Application for a Non-Material Amendment Following a Grant of Planning Permission

Construction of nine dwellings and associated works

20/02915/FU

HOUSE TYPE F - ELEVATIONS

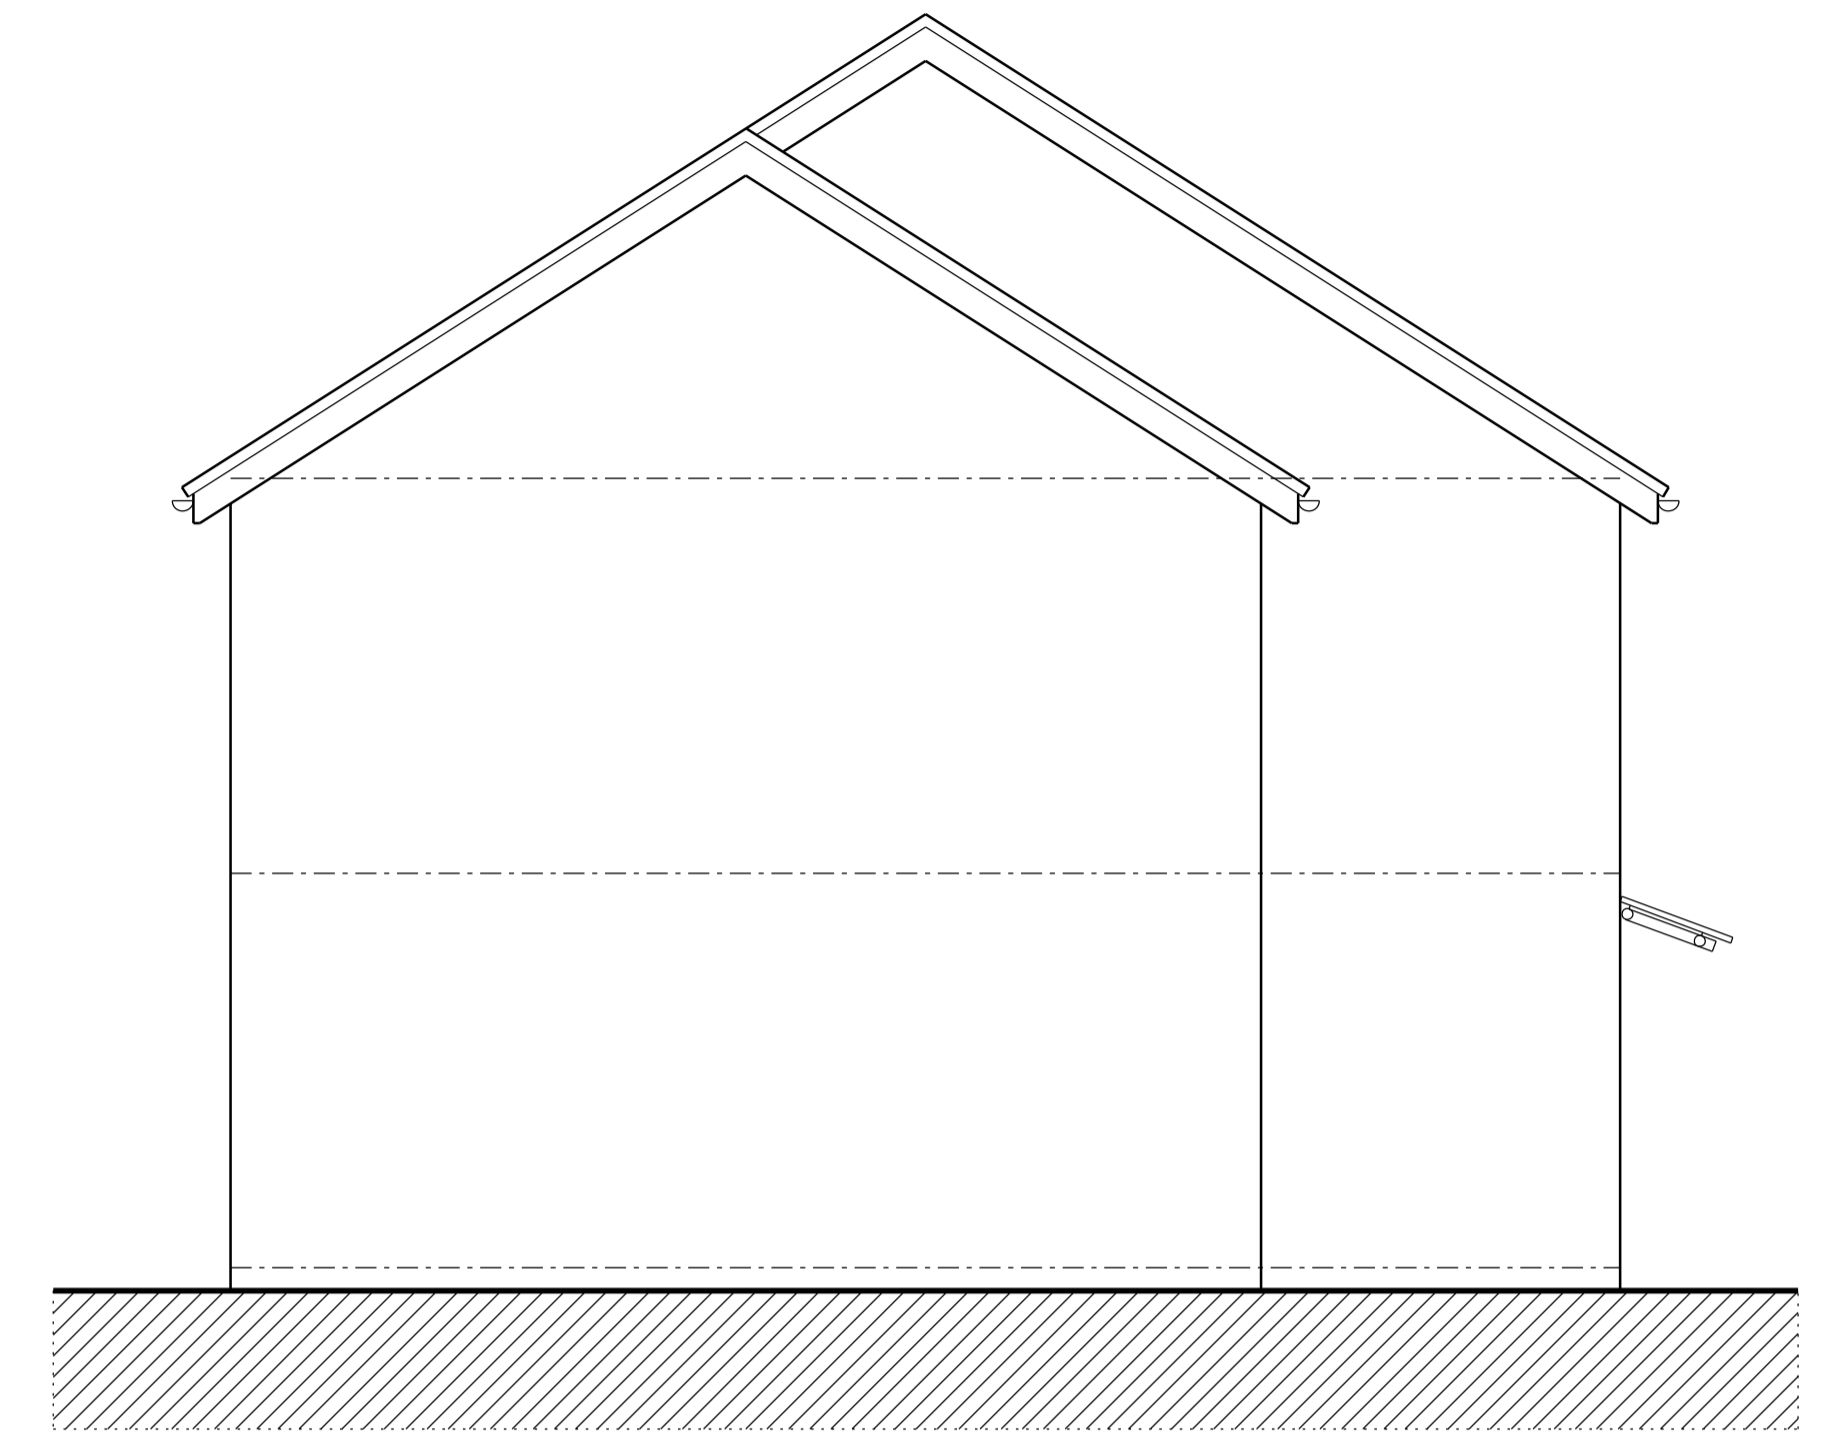
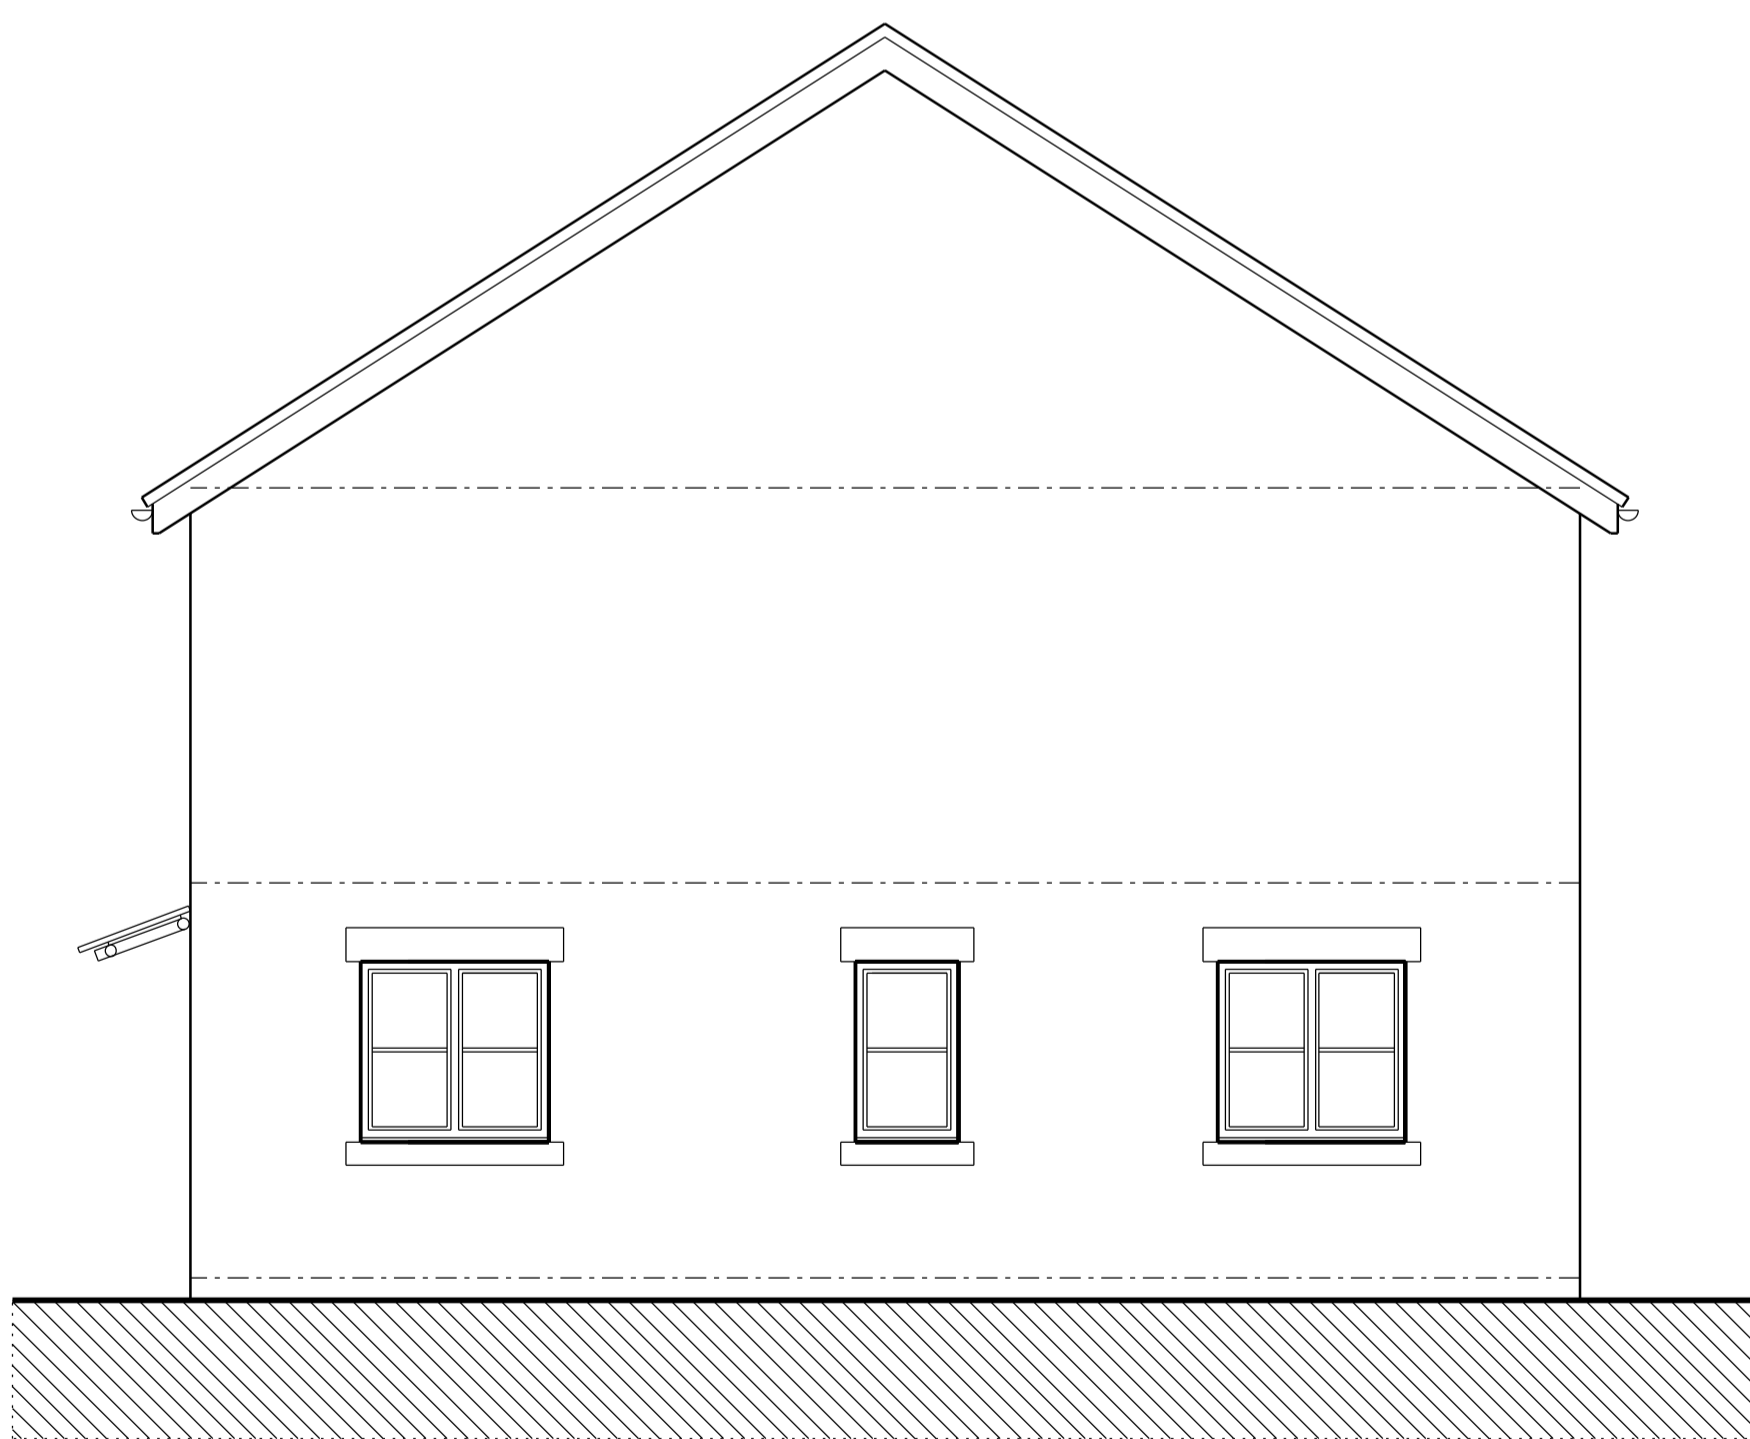
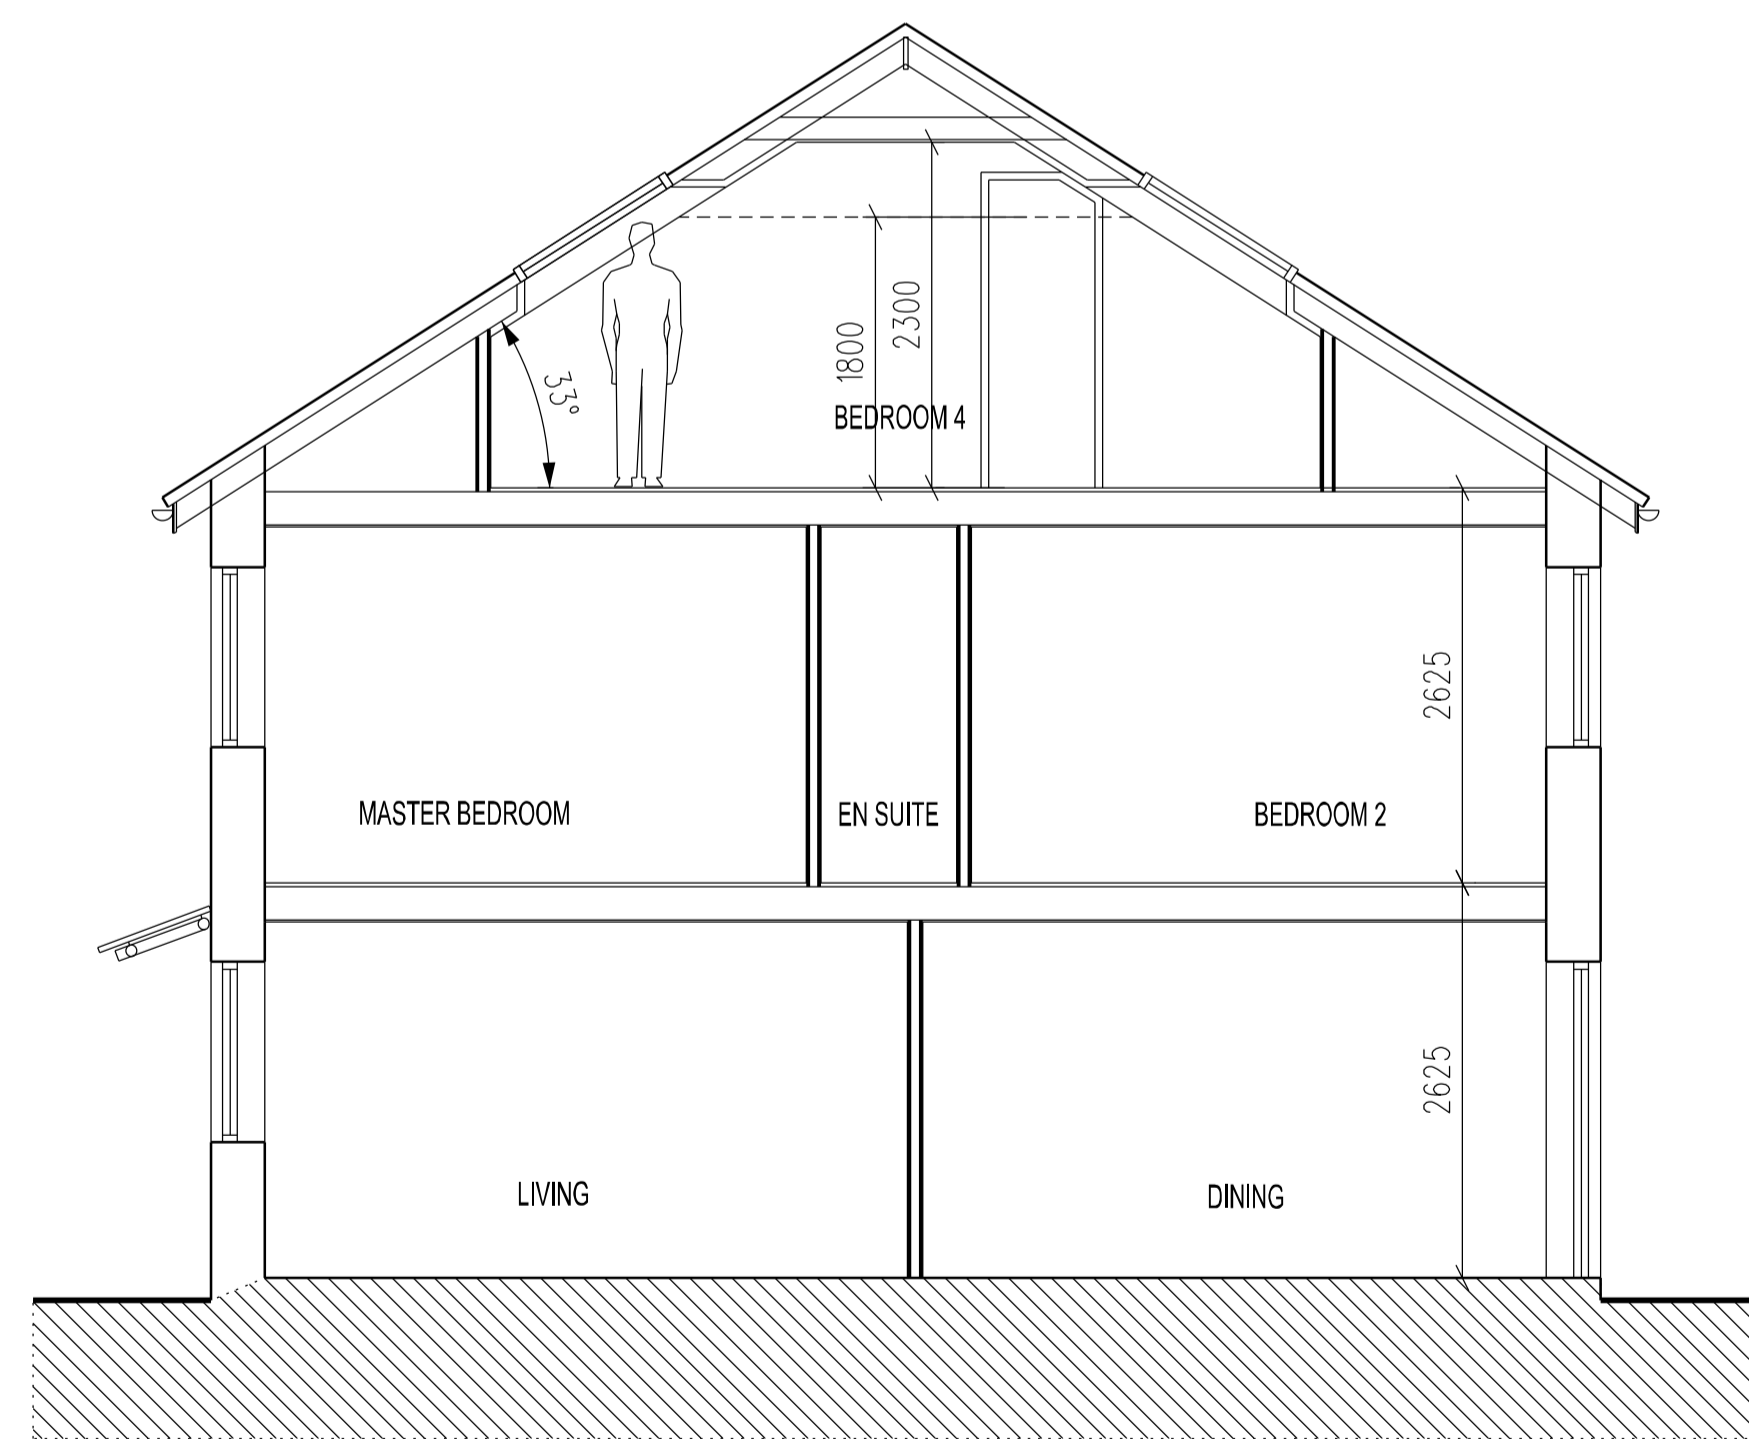
There has been an added ground floor garage to both house type C and house type F as well as an increase in floor area to both of these houses.

House Type F elevations replaced with Rev J
